7 April 2022

Ref: EPG/2022/TFW/CSS/Q002/01

### **Coelbren Health Centre, SA10 9PE, Mine and Landfill Gas Risk Assessment**

**FIGURE 1**

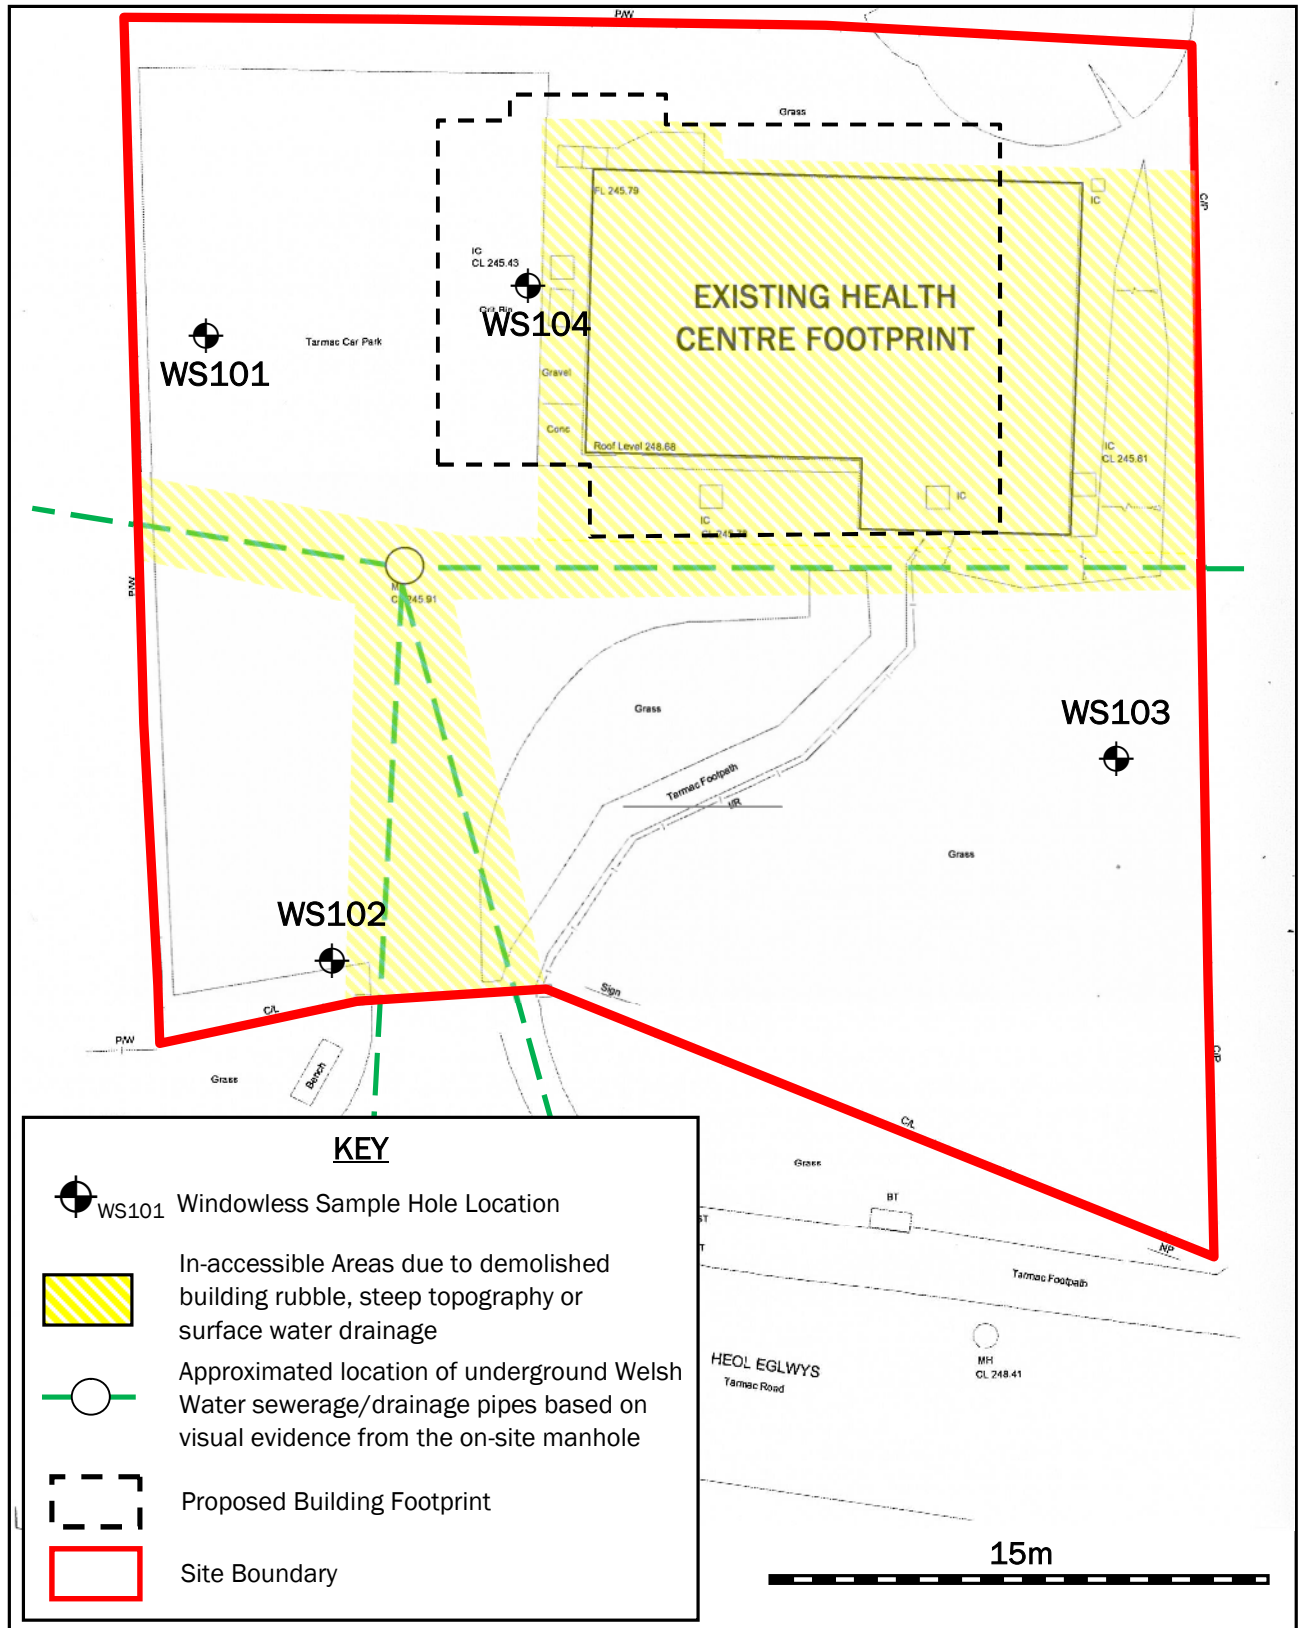
The ESP Ground Gas Risk Assessment includes gas monitoring results from gas monitoring in four monitoring wells at the site. Two wells were monitored on 6 visits, one on five and one on two visits. Four of the visits were at low atmospheric pressure.

BS8485 and BS8756 indicate that steady state values of gas monitoring data should be used in a risk assessment. In particular peak flow rates on opening a gas tap are not representative of the surrounding gas regime. Steady state results show methane <0.1%, carbon dioxide up to 4.6% and flow rates up to 0.4l/h. The slightly elevated carbon dioxide concentrations are caused by biological respiration of organic material in the Glacial Till as shown in the Ternary plot in the Figure below. All the hazardous gas flow rates are less than 0.7l/h and the site is characterized as Characteristic Situation CS1 in accordance with BS8485: 2015 + A1: 2019.

Even plotting the peak data which is not representative of site conditions shows the gas concentrations recorded are not indicative of hazardous emissions. Again all the hazardous gas flow rates are less than the limit for Characteristic Situation CS1. Even a worse case check gives a GSV of 0.0138l/h which again indicates CS1. Given the CSM discussed above and absence of any significant high risk source of gas, plus the ternary plots it is reasonable to leave the classification at CS1 even though one reading recorded above 1% methane and two results were above 5% carbon dioxide. This is in line with the guidance in BS8485.

The site is classified as Characteristic Situation CS1 and gas protection measures are not required in the building when it is changed to residential use.
